Section 55 Acceptance of Applications

A14 Cambridge to Huntingdon – Section 55 Application Checklist¹

**A14 WESTBOUND MAINTENANCE OFFSLIP WORK NO. 5 - WORKS PLANS SHEET NO. 7 (GENERAL ARRANGEMENT SHEET NO. 6)**

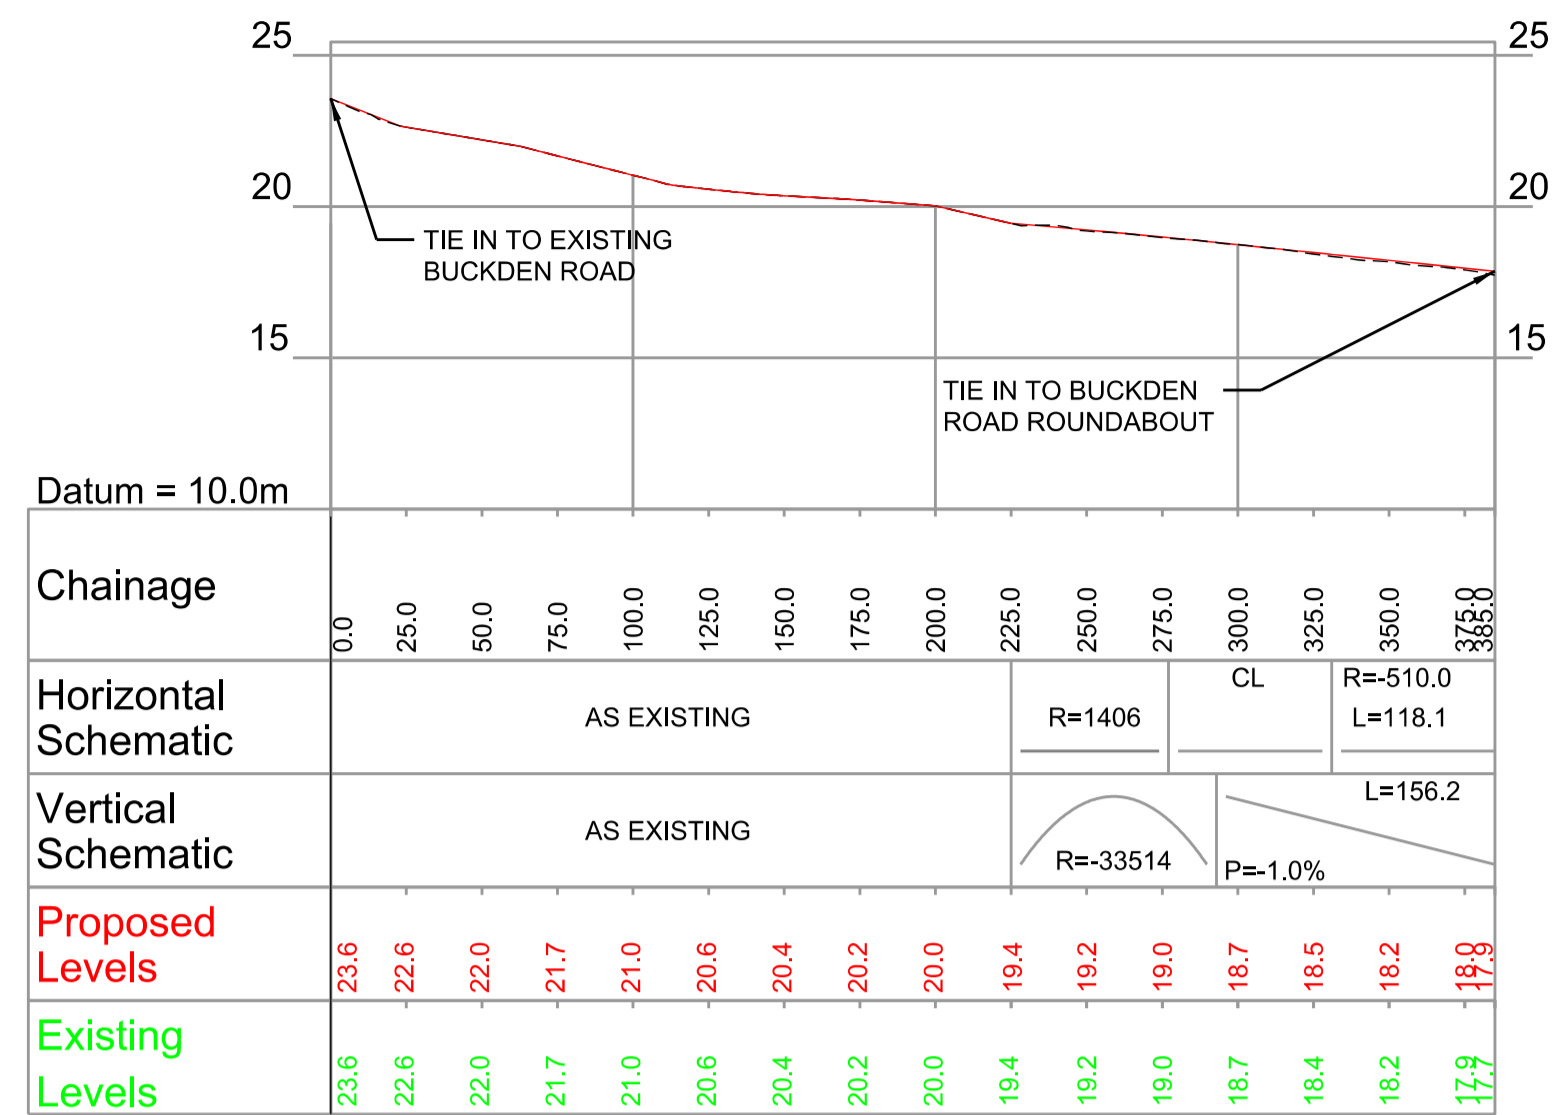
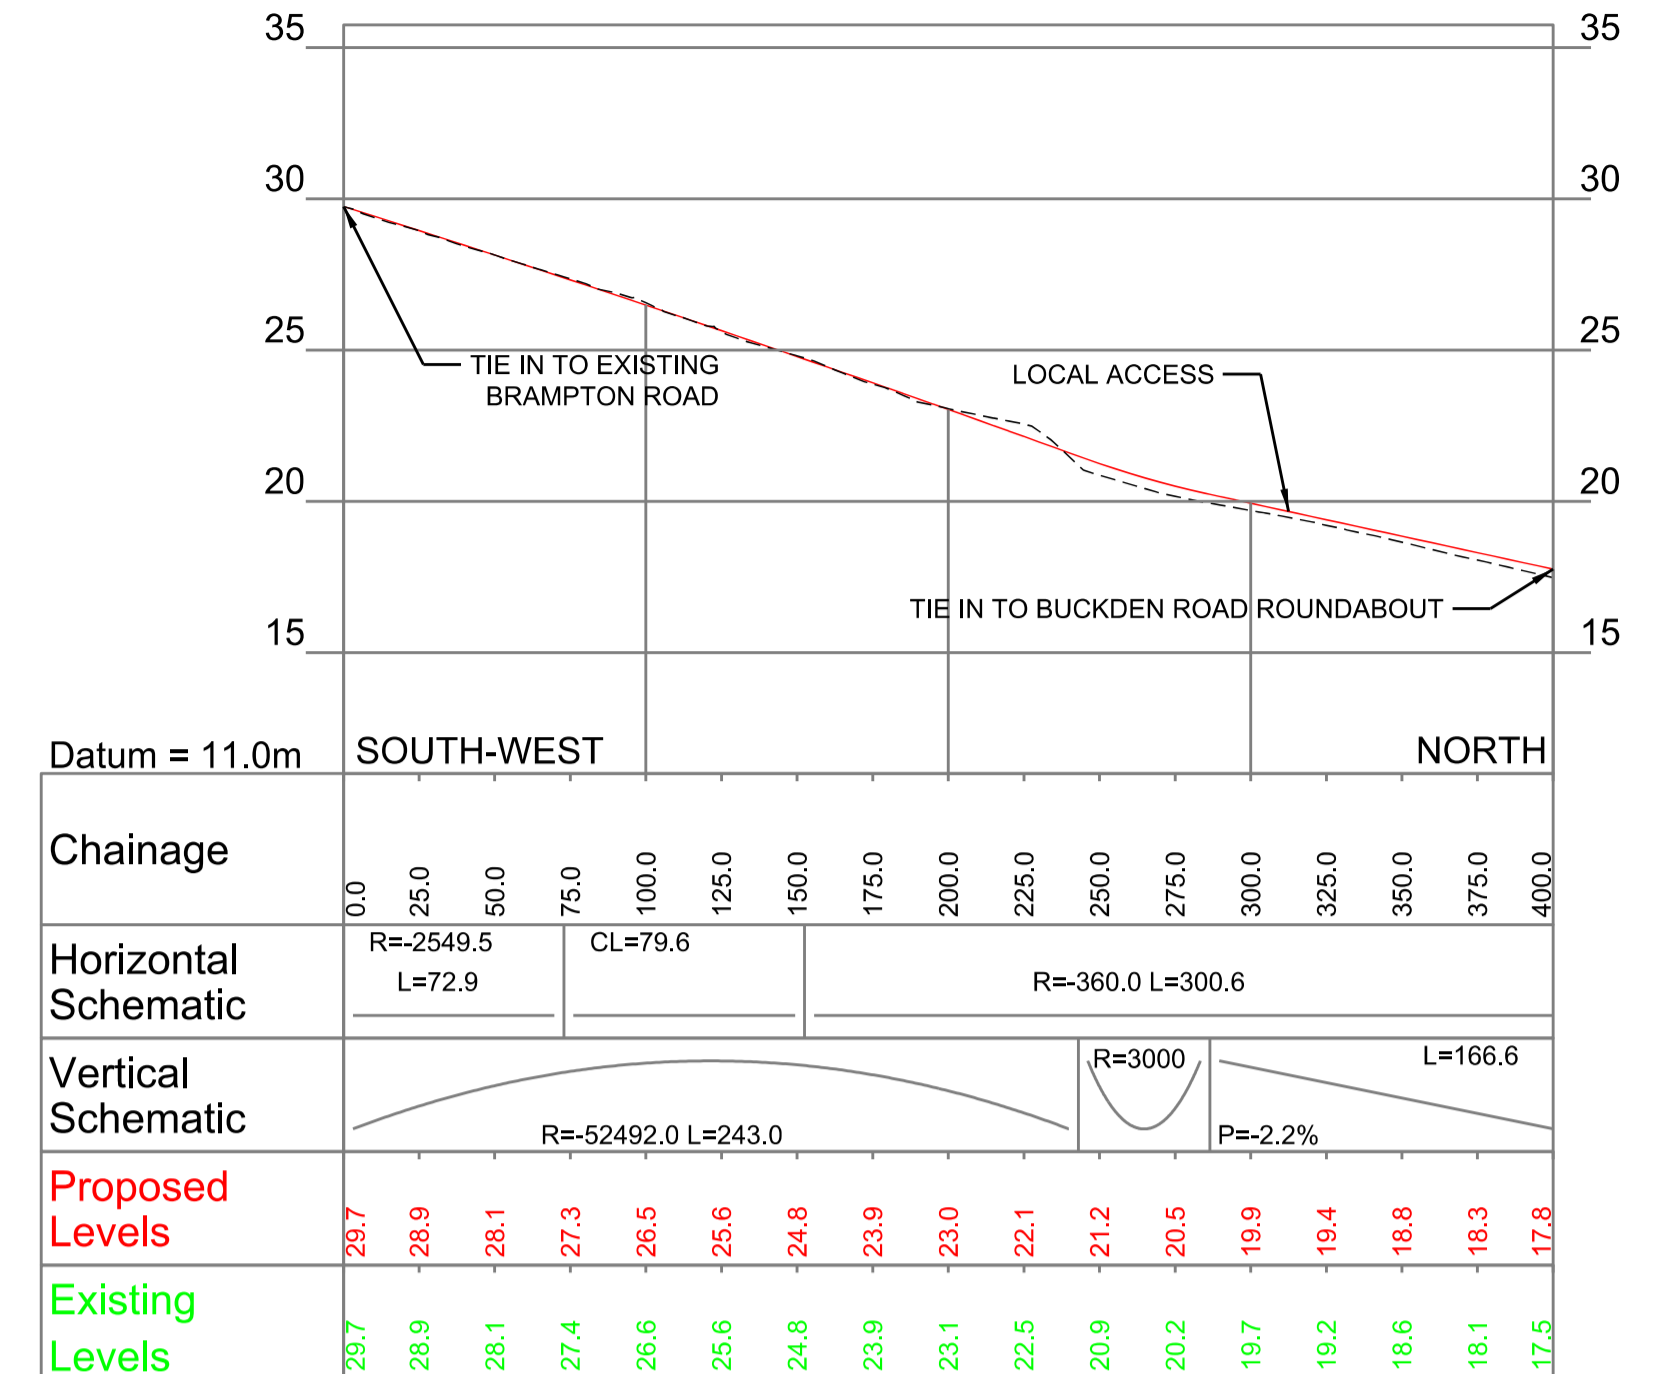
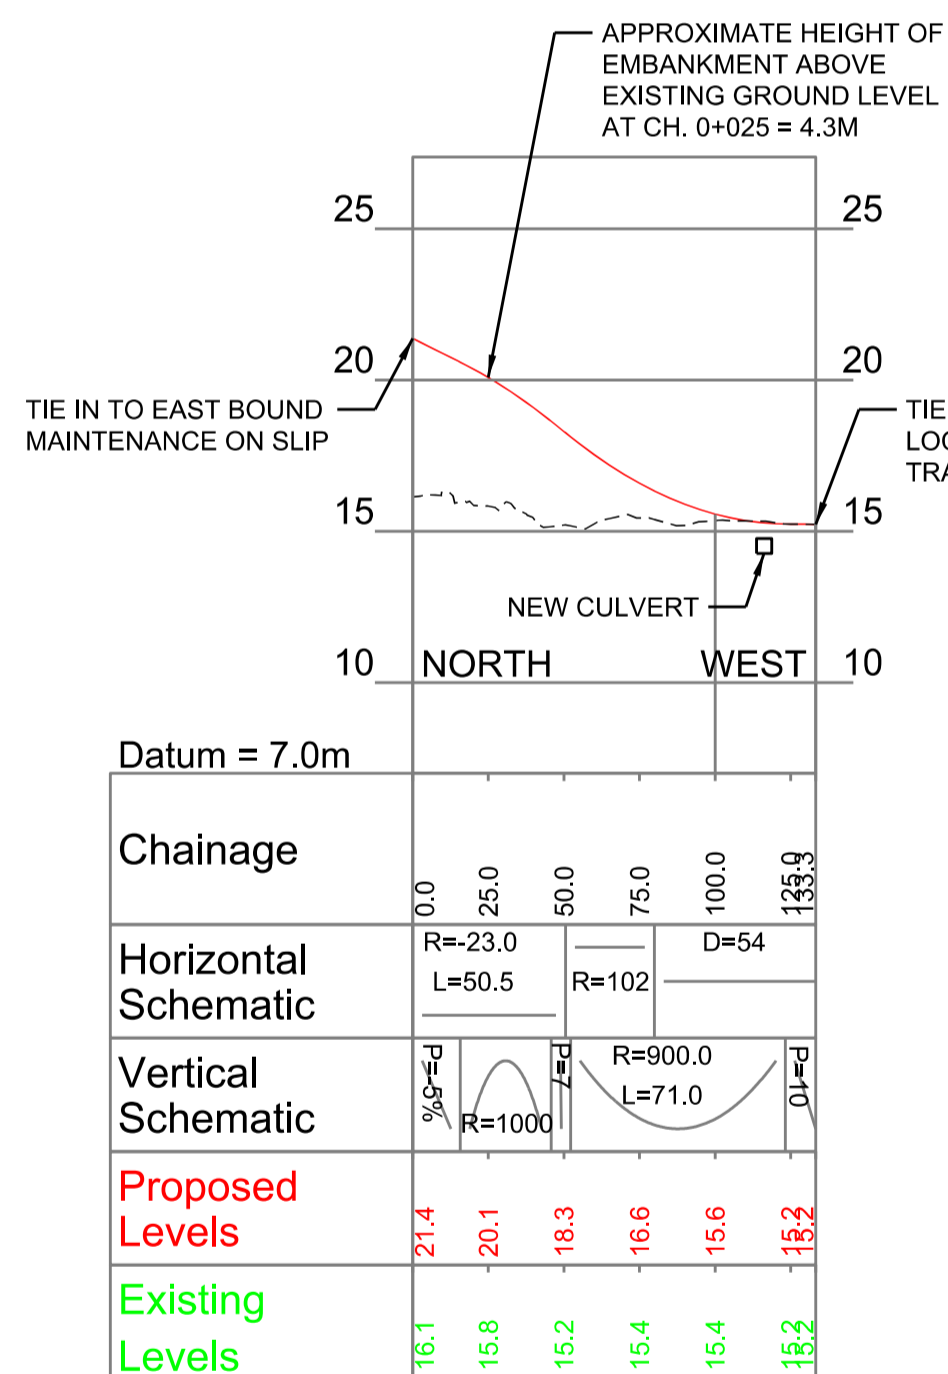
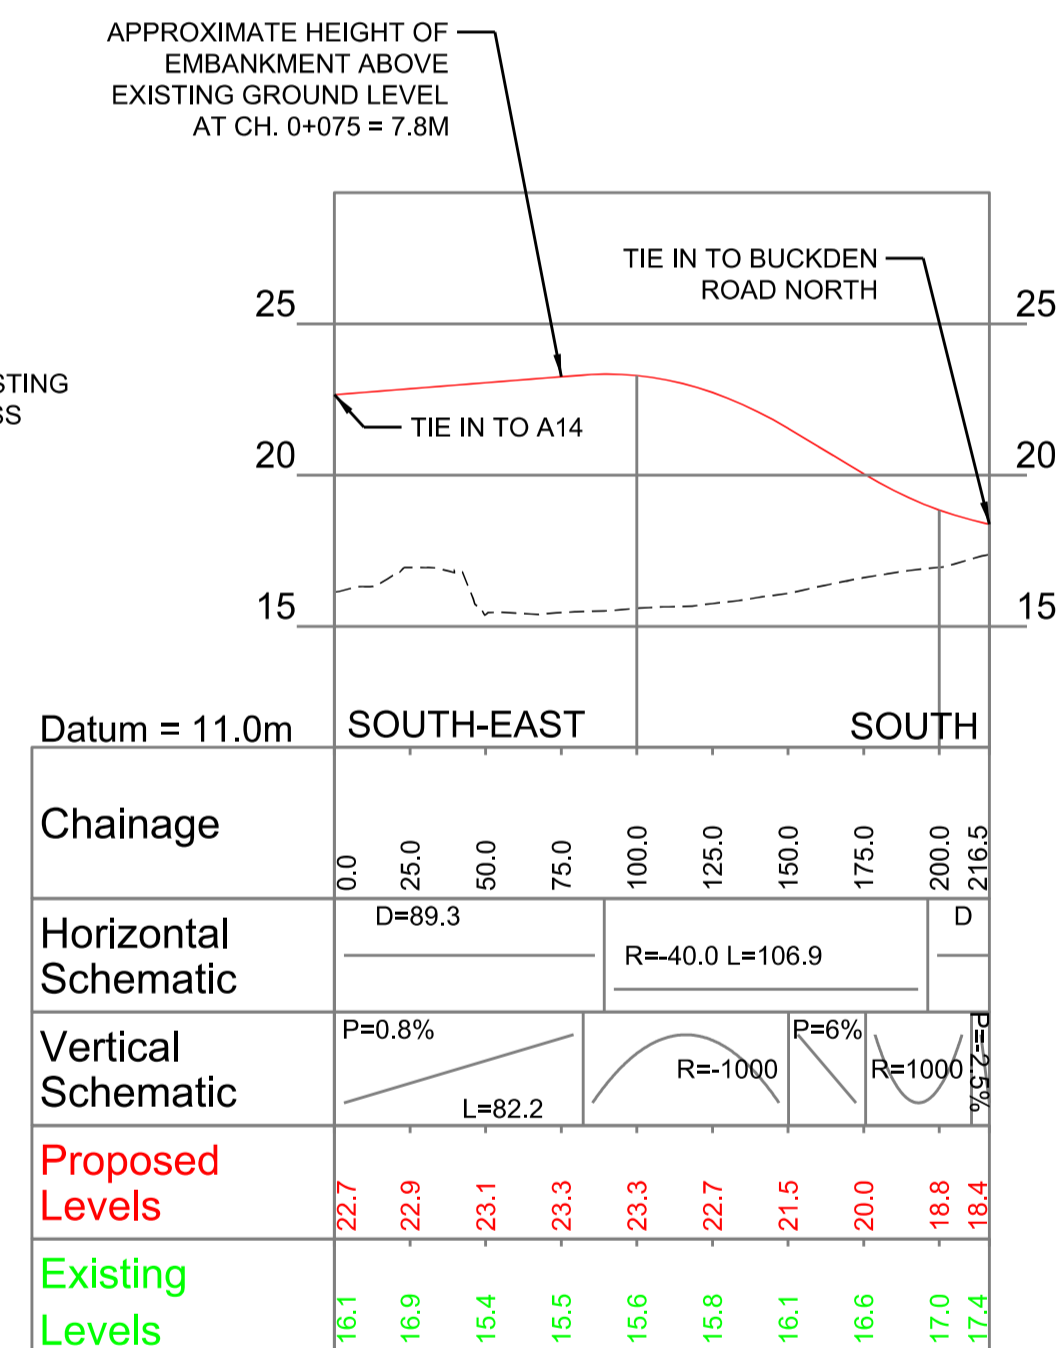
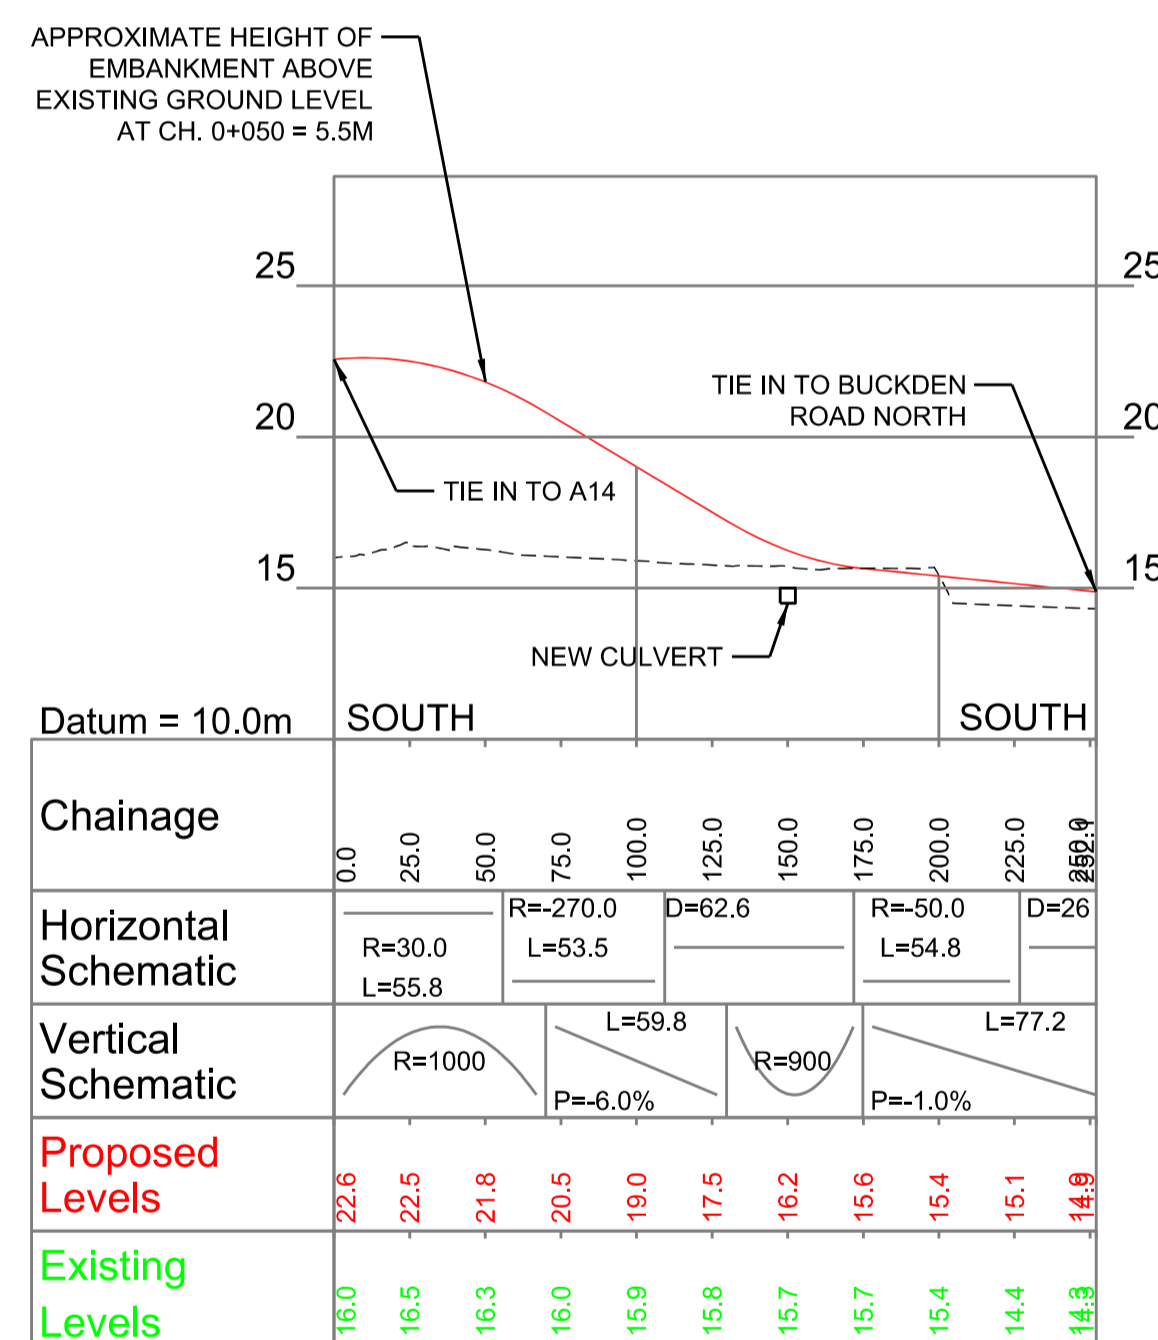
These drawings are generally to a lower standard. The heights of proposed bridges and embankments must be scaled; more detailed elevations would be preferable.

Most of the publically accessible carriageways are provided in section, though some accommodation roads and approaches to minor roundabouts have been omitted contrary to part (b).

There are a number of labelling errors which present a barrier to comprehension:

- A14 Mainline (sheet 3) – transverse A1 labelled as A14
- A1 to A14 Westbound interchange link (sheet 9) – transverse A1 labelled as A14
- A14 Eastbound Maintenance Offslip (sheet 11) – onslip labelled as offslip
- A1198 Ermine Street North Roundabout Link (sheet 12) – should state that it links north and south roundabouts
- Westbound Diverge Slip Road (sheet 14) – Emergency maintenance access labelled as diverge slip road
- Bar Hill Junction Services Access (sheet 22) – northwestbound merge labelled as northeastbound merge
- A14 westbound link (sheet 33) – westbound labelled as eastbound

Section drawings should be arranged logically and each drawing should be labelled with cardinal points. Minor roads in Huntingdon centre should be much more clearly differentiated. Further advice on this is issued separately.
